KITTITAS COUNTY

MEMORANDUM

TO: All Staff
FROM: Public Works Plan Review Team
DATE: July 8, 2025
SUBJECT: BL-25-00009 Wales

RECORD OF SURVEY FOR BOUNDARY LINE ADJUSTMENT  
WITHIN THE SW1/4 OF SECTION 33, TOWNSHIP 20 NORTH, RANGE 16 EAST, W.M., KITTITAS COUNTY, WASHINGTON

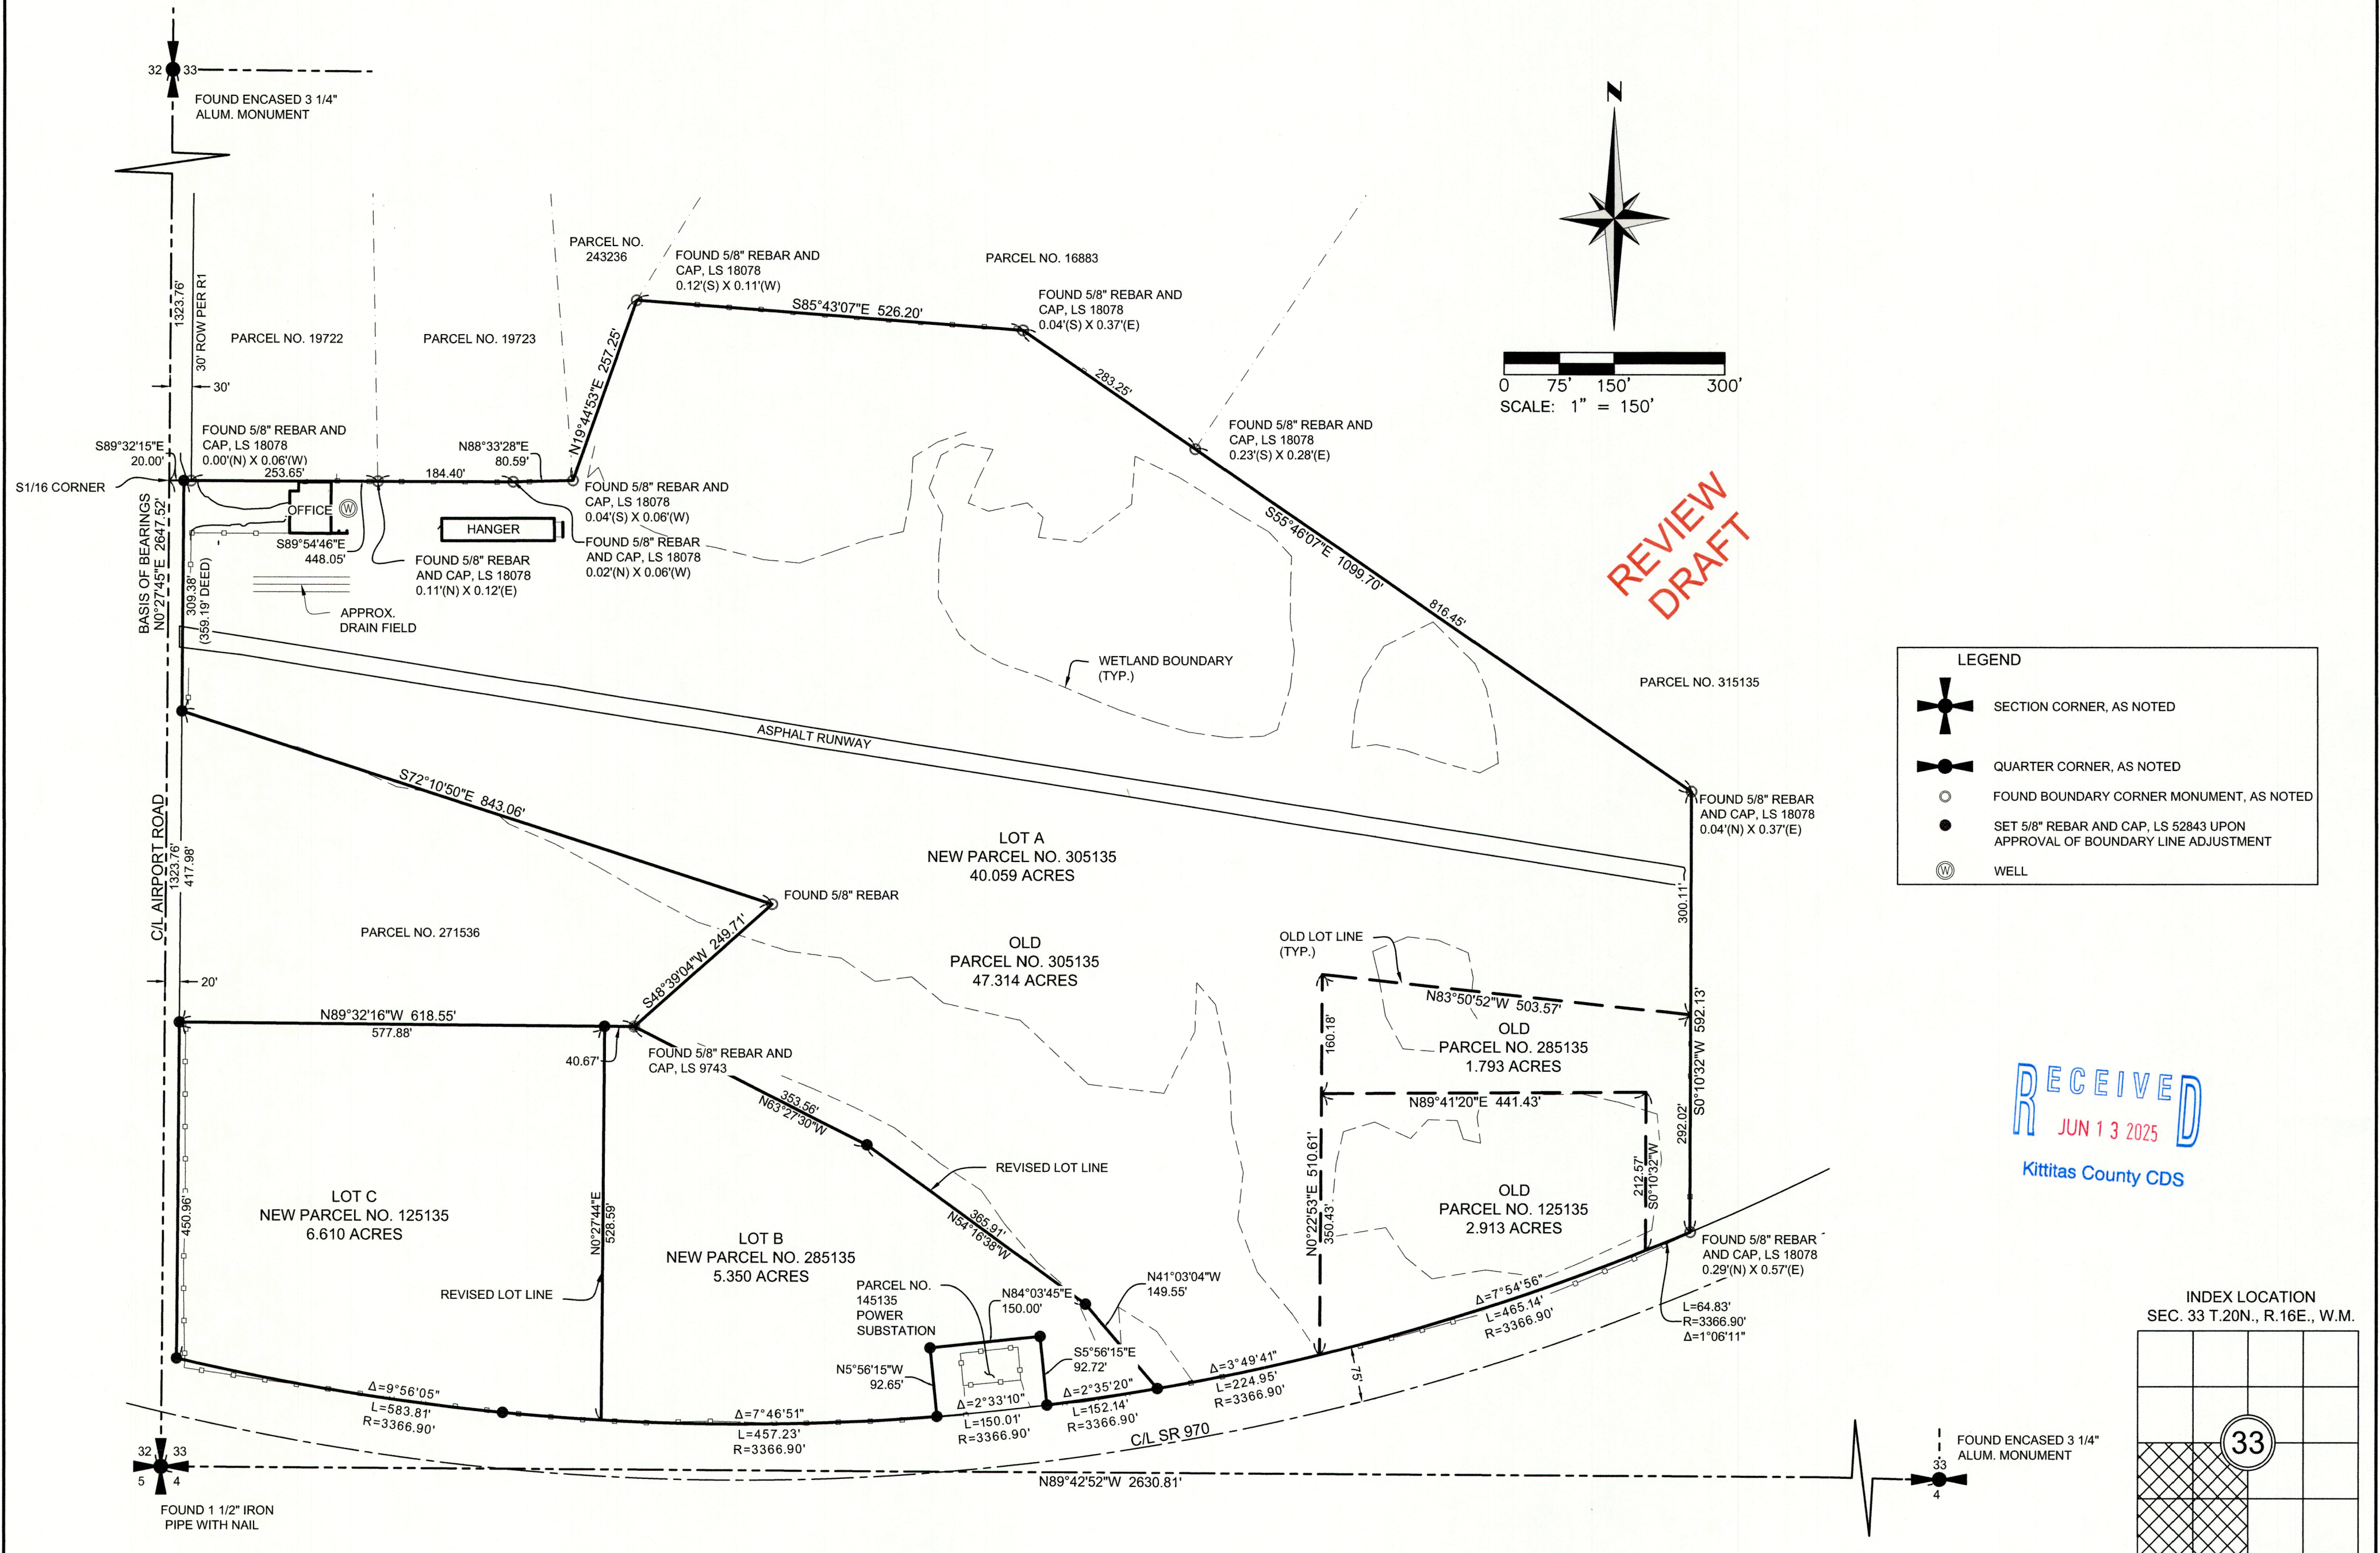
SURVEY	<ol style="list-style-type: none"> 1. Please revise survey note #1 to reflect application no. BL-25-00009. 2. Please include width, surfacing and ownership for road right of way (EX: Var. Width County R/W – Paved) <p>OF NOTE (suggestions, not requirements for approval)</p> <ol style="list-style-type: none"> 3. Labelling APN 271536 and 145135 as “Not A Part” may clarify limits of this BLA. 4. Lot Closures not provided by applicant, and no lot closures were reviewed. (JT)
TRANSPORTATION CONCURRENCY	No Comments. (RC)
